Environmental Health Consultation Response

To	Amber Willard
Date	01-08-2026
Planning Ref	EP/65/26/DOC
Site Description	19 - 21 Sea Road East Preston Littlehampton West Sussex BN16 1JN
Date of Application	2026-07-13 00:00:00
Category	Discharge Of Condition
Recommendation	No Objection No Objection — with conditions Objection Holding Objection

I have reviewed the submitted information provided to for the discharge Conditions 3, 4, 5 and 6 of planning permission Planning Response EP-121-25-PL - 19 - 21 Sea Road, East Preston, Littlehampton, West Sussex, BN16 1JN.

Figure 6. North Elevation - Updated Fan Location.

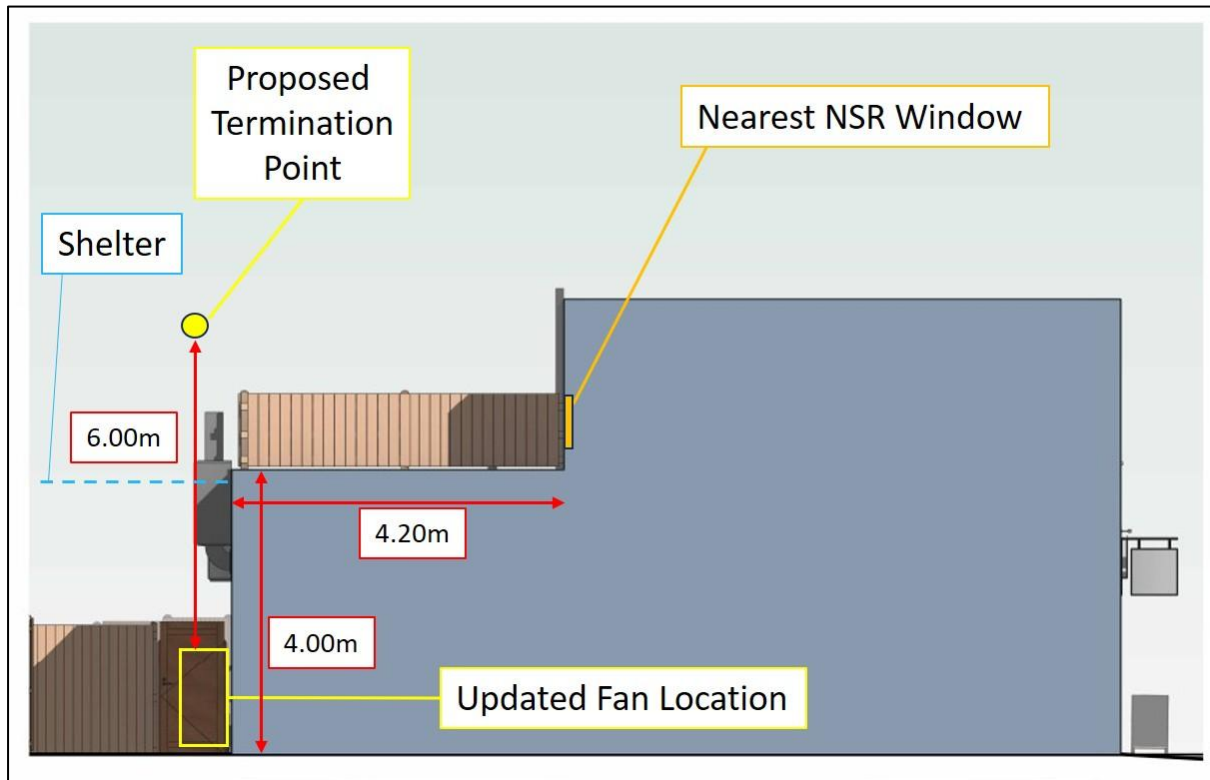
The submitted information does not provide sufficient details of the proposed odour control measures and therefore fails to demonstrate how fumes and cooking odours will be effectively treated before discharged to the atmosphere.

This matter is particularly important given that the proposed kitchen extract termination point appears to be directly in line with windows of the flat above the premises. In such circumstances, we would normally expect the applicant to undertake an odour impact assessment in accordance with the current EMAQ guidance to demonstrate that the proposed extraction and filtration system will not adversely affect neighbouring residential amenity.

Figure 14. Sound Insulation Results Graph – GF to 1F

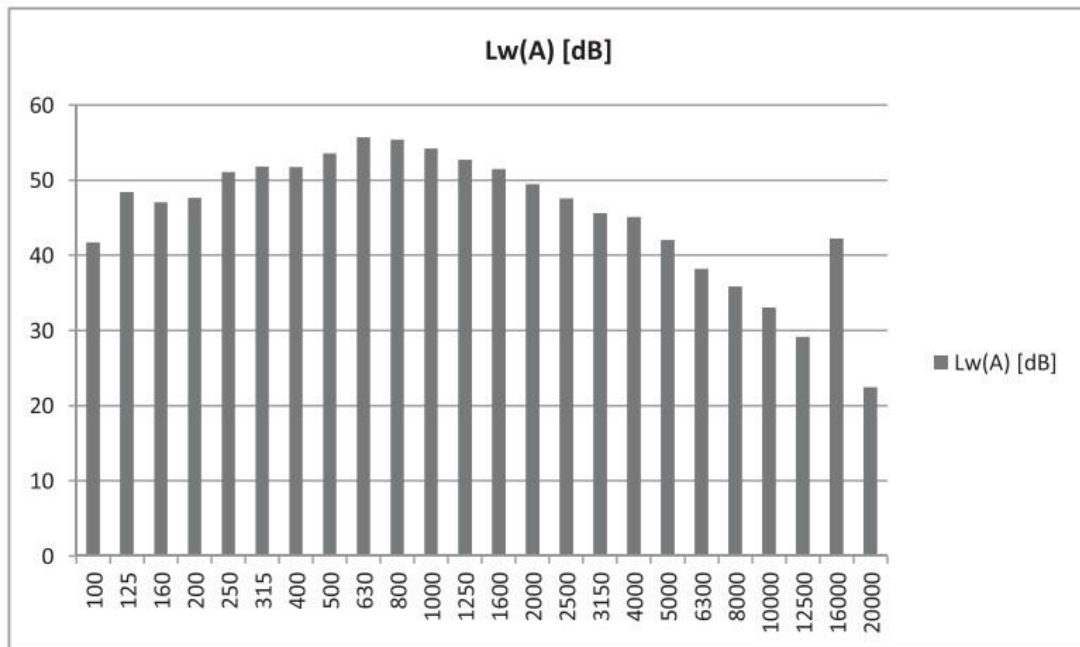
The submitted acoustic report demonstrates an achieved sound insulation value of 52 dB (DnT,w + Ctr), which exceeds the standard required by the condition. On this basis, I have no objections to the discharge of Condition 5.
